Recommendation Report for Planning Permission

REF NO: FP/86/21/PL

LOCATION: 7 Ambleside Close
Felpham
PO22 8NG

PROPOSAL: Erection of 1 No. 3 bed dwelling (resubmission following FP/179/20/PL). This site is in CIL Zone 4 & is CIL Liable as new dwelling.

PROPOSED SITE LAYOUT & MASSING

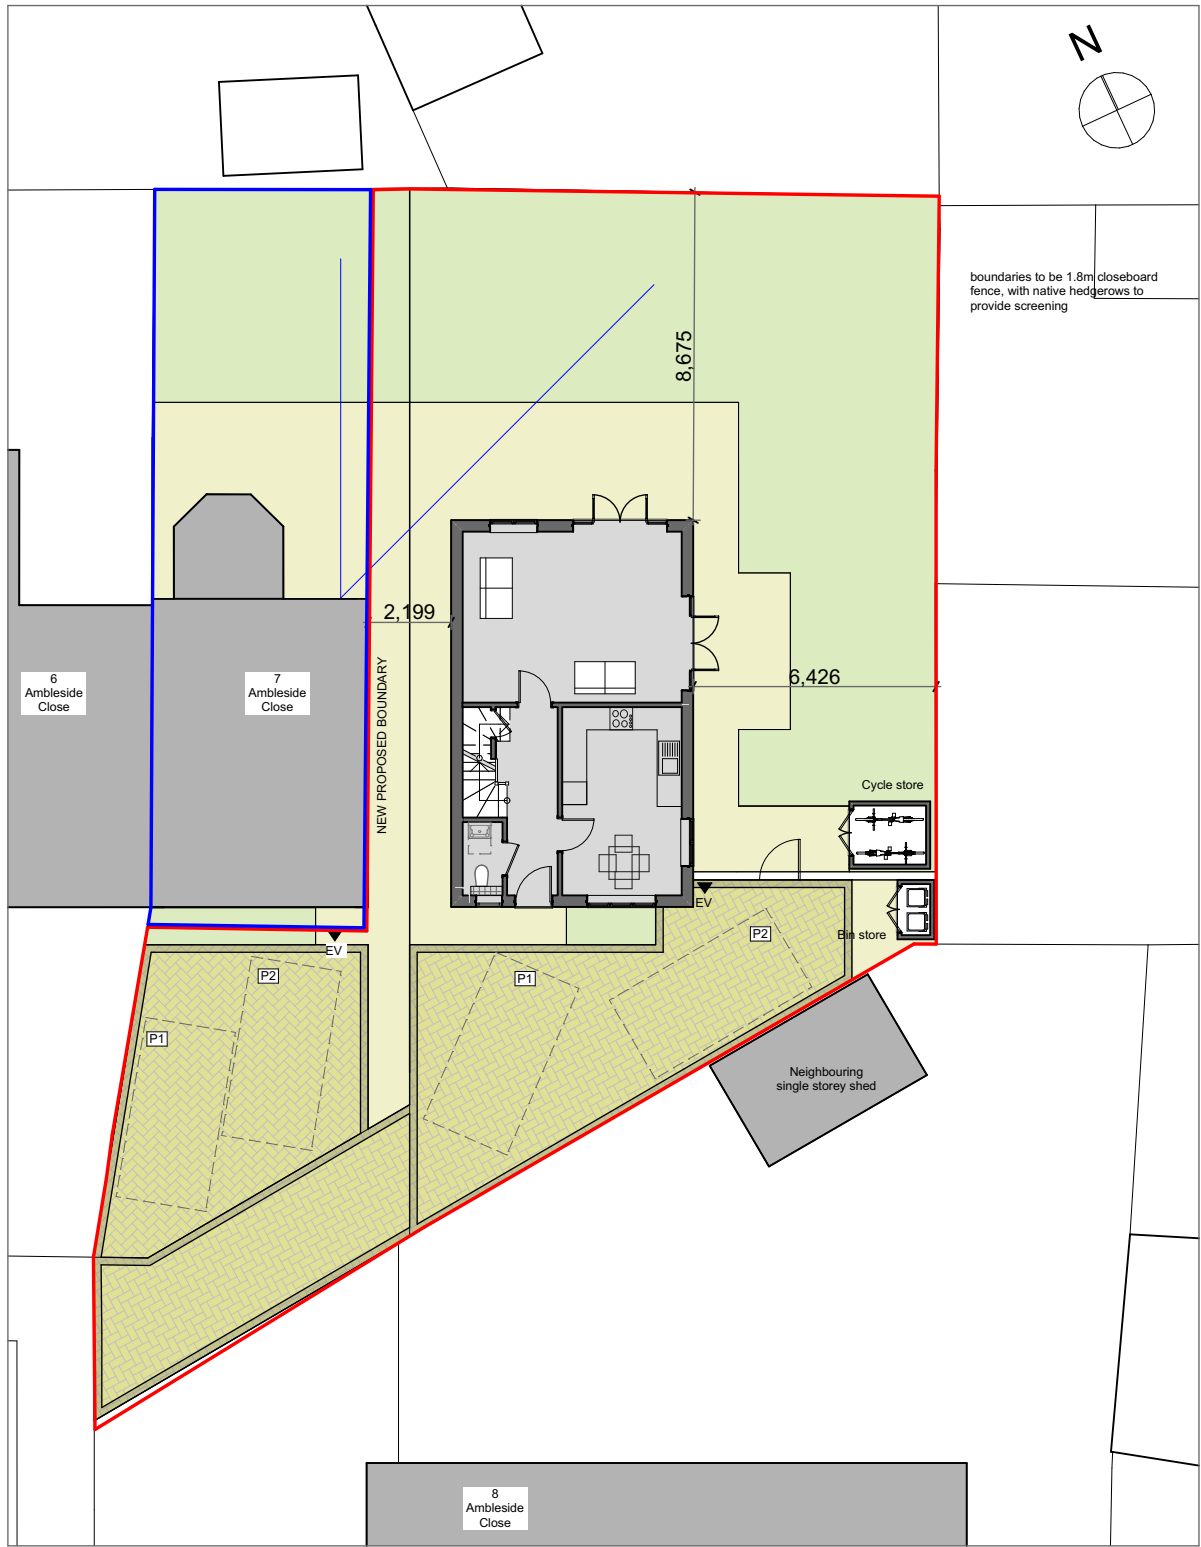
Arun District Council's Parking Standards Supplementary Planning Document (January 2020) outlines the approach to parking at new developments. 2 parking spaces are shown on the site layout which satisfies the requirement of the SPD for two 3 bed dwellings in Parking Behaviour Zone 2 (2 parking spaces per dwelling).

The proposal will utilise the existing access onto Ambleside Close, providing a shared driveway and two parking areas for both the existing and proposed dwellings.

The proposal provides rear garden space with a depth of 8.7m which would not satisfy the requirement of Arun Design Guide, however land is provided to the side of the property and it would comply with policies D DM1 & D DM2 and with the guidance in the NPPF (para. 127). However it would be at the expense of the host property which would be squeezed between properties with 5m wide rear garden of less than 50 sqm in area and would result in a provision of an inadequate amenity space for No 7. The proposal would only partially satisfy the requirements of Nationally Described Space Standards.

Project/Address	New Build Dwelling 7 Ambleside Close Felpham	Drawing	Proposed Floor Plans
		Drawing Name	4000_PL_003.1
		Scale	As shown @ A3
		Date	July 2020
Client	Carolynn Bottomley	Drawn By	Ian

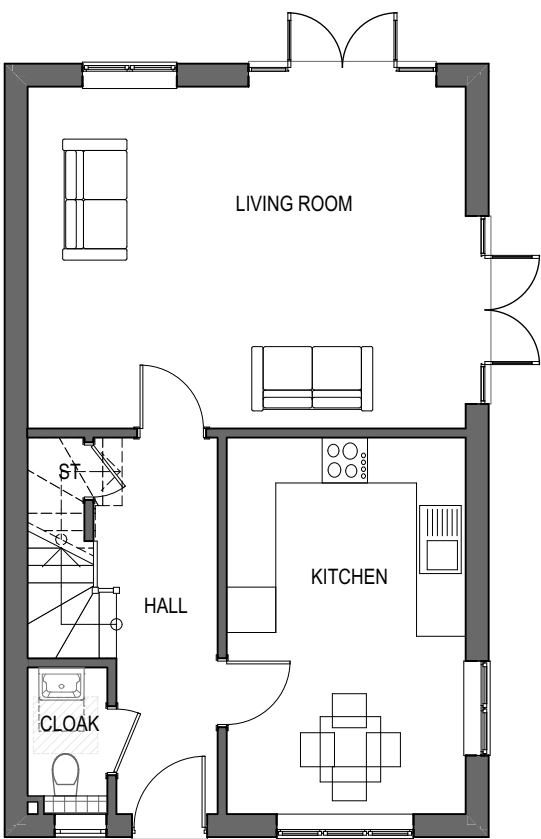
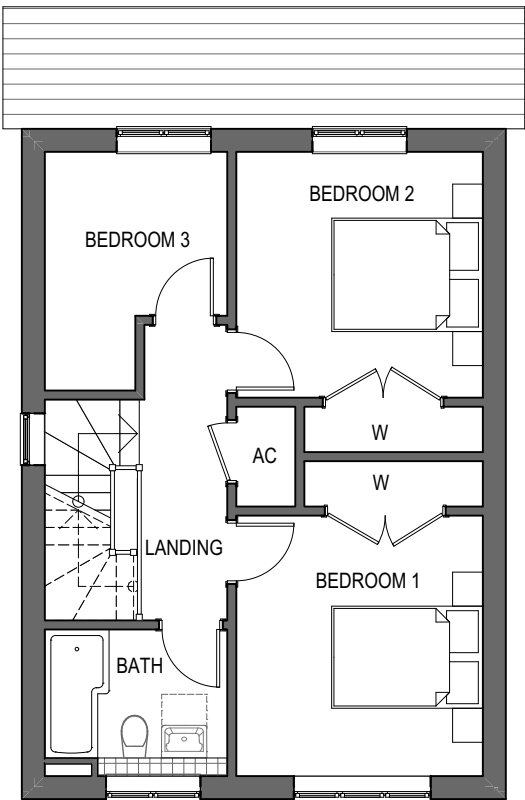
The proposal relates to gross internal floor space of approximately 103sqm which would satisfy the requirement for a 3 bed dwelling size (102 sqm for 3 bed/5persons, 2 storey dwellings). Nationally Described Space Standards require a single bedroom has a floor area of at least 7.5m² whilst bedroom 3 would have 6sqm only.

Project/Address	New Build Dwelling 7 Ambleside Close Felpham	Drawing Drawing Name Scale Date	Proposed Elevations 4000_PL_004.1 As shown @ A3 July 2020
Client	Carolynn Bottomley	Drawn By	Ian
Note: these drawings are prepared for building regulations purposes only

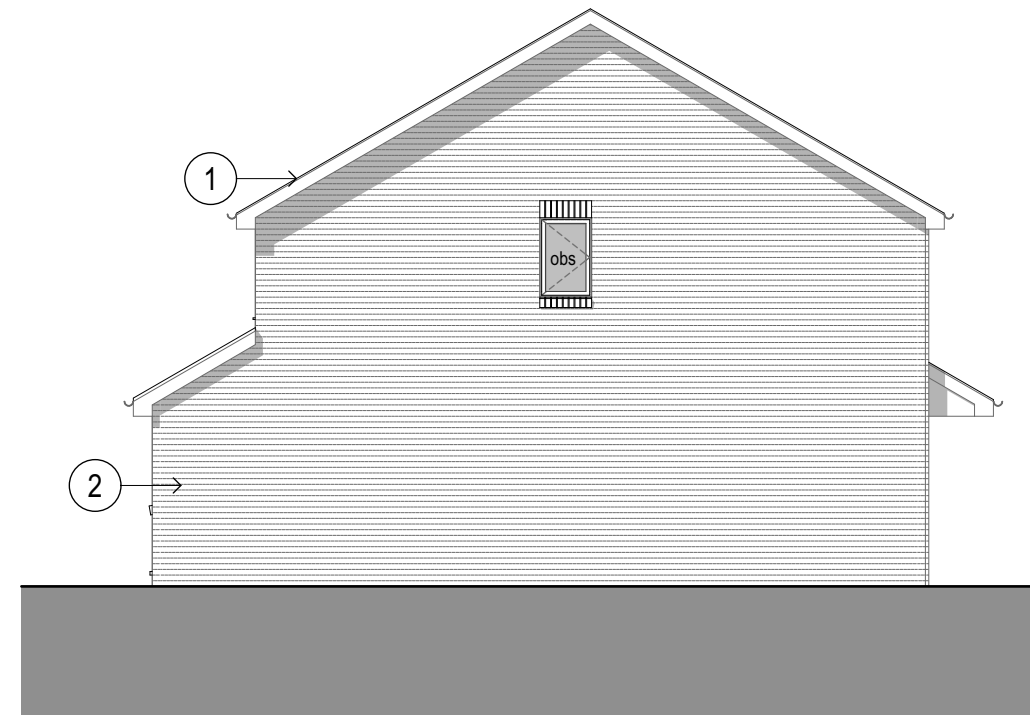
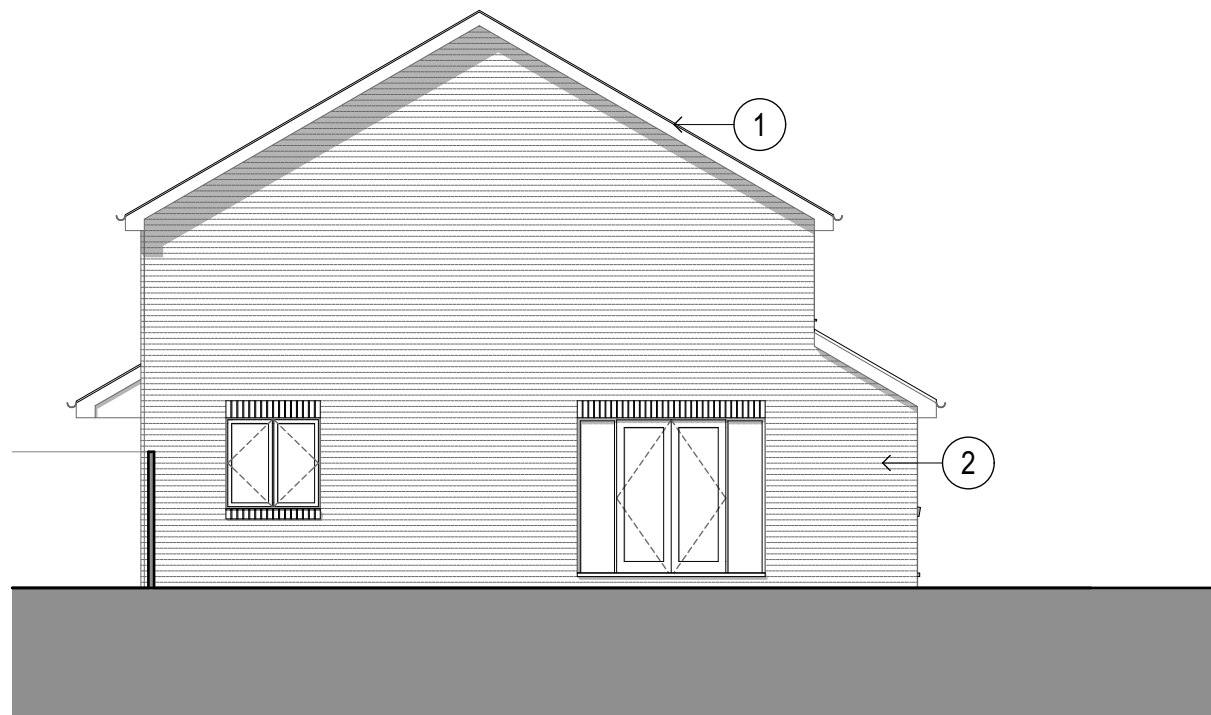
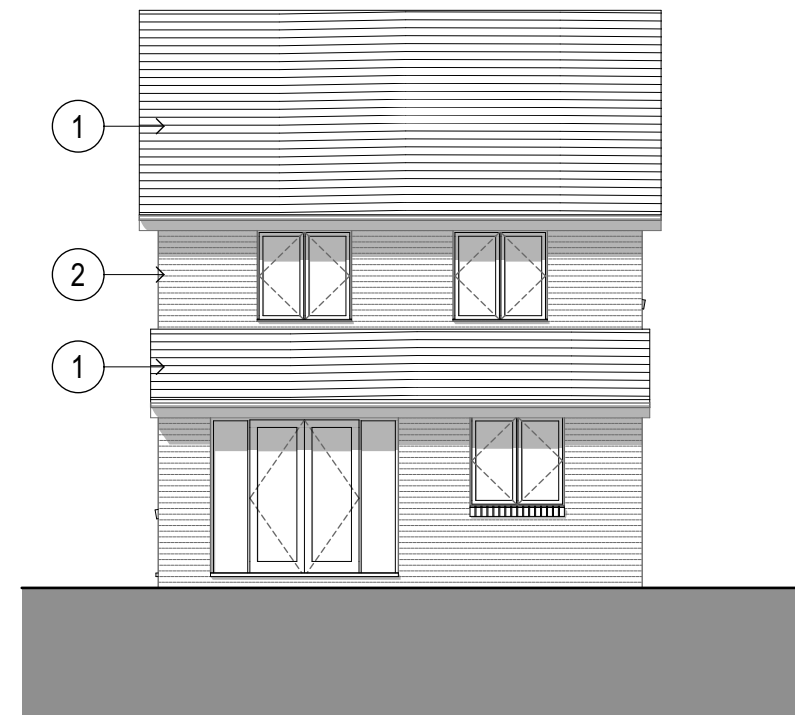
The south-east unanimated elevation of the dwelling would be within a distance of 6.3m (instead of previously 1.25m) therefore the impact on the living conditions of the dwelling to the south-east would be not unacceptable. However, the relationship of the dwelling to No 8 Ambleside Close would be still unchanged since the proposed is marginally closer albeit the front window at first floor level would be smaller but within a separation distance of 14m from the side elevation of 8 Ambleside Close with habitable windows and would result in a direct overlooking. It would look directly in to the side garden of that property (which contains the most private amenity space due to the lack of a significant rear garden). Arun Design Guide Supplementary Planning Document, Part H04 (Residential Amenity) requires the minimum separation distance of 16m between habitable rooms of properties facing each other. The proposed first floor windows on the north-eastern elevation serving bedrooms would overlook rear garden of property 7 Thirlmere Way and the rear of southern end of Derwent Grove No 14.

Project/Address	New Build Dwelling 7 Ambleside Close Felpham	Drawing Drawing Name Scale Date	Proposed Street Scenes 4000_PL_006.1 As shown @ A3 July 2020
Client	Carolynn Bottomley	Drawn By	Ian

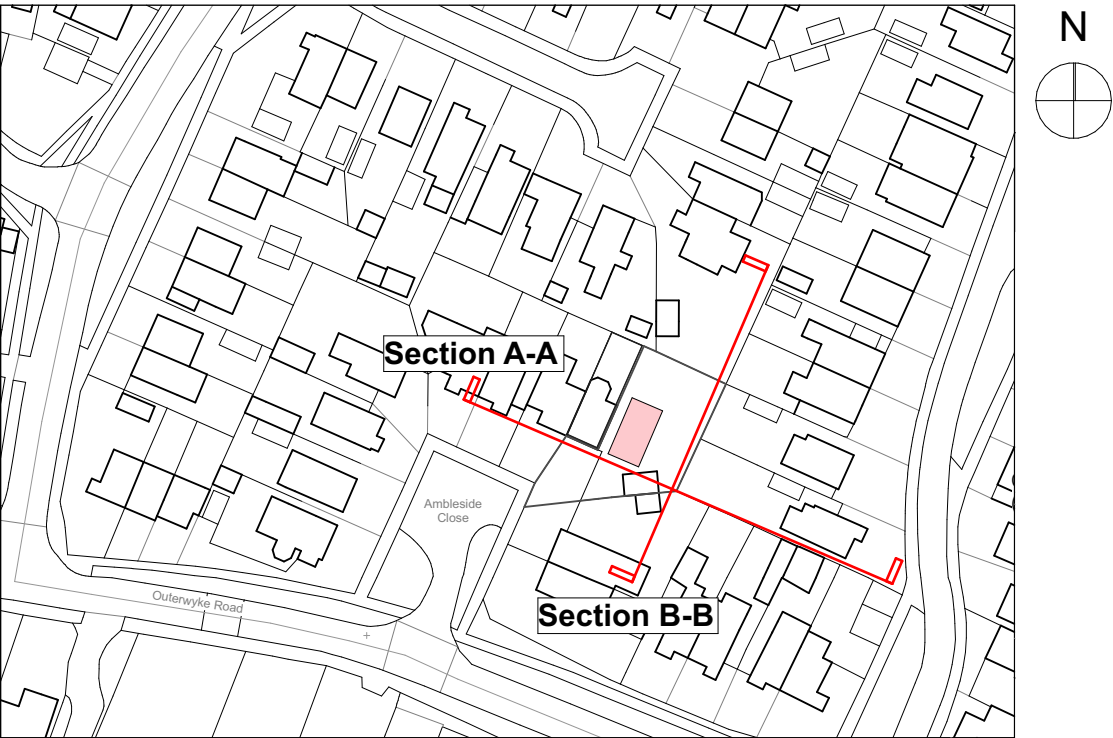
The site is garden land to the east of 7 Ambleside Close, a residential cul-de-sac characterised by a very well set back 2 storey semis and detached dwellings with rather small gardens apart from two corner plots (7 and 4) which benefit from spacious gardens of an irregular shape. Whilst No 4 benefits from an extensive single storey side extension, narrow to the front and widening to the rear reflecting the shape of the plot, no 7 before clearance of trees and shrubs benefitted from a garden contributing to the feel of openness. The side extension of No 4 is hardly visible in the street scene. It should be stressed that the pair of semis within a small cul de sac is shifted to the right therefore the access to the site is more complicated and the proposed dwelling would not be a part of the close but the substantial building, albeit the footprint of current proposal is smaller than that refused, standing alone within garden in a vicinity of No 7 Ambleside Close with its 'active' elevation facing to the side elevation of No 8 Ambleside Close. Therefore the 'street-scene' as shown in drawing 4000_PL-006.I would be available to the residents of No 8 only.
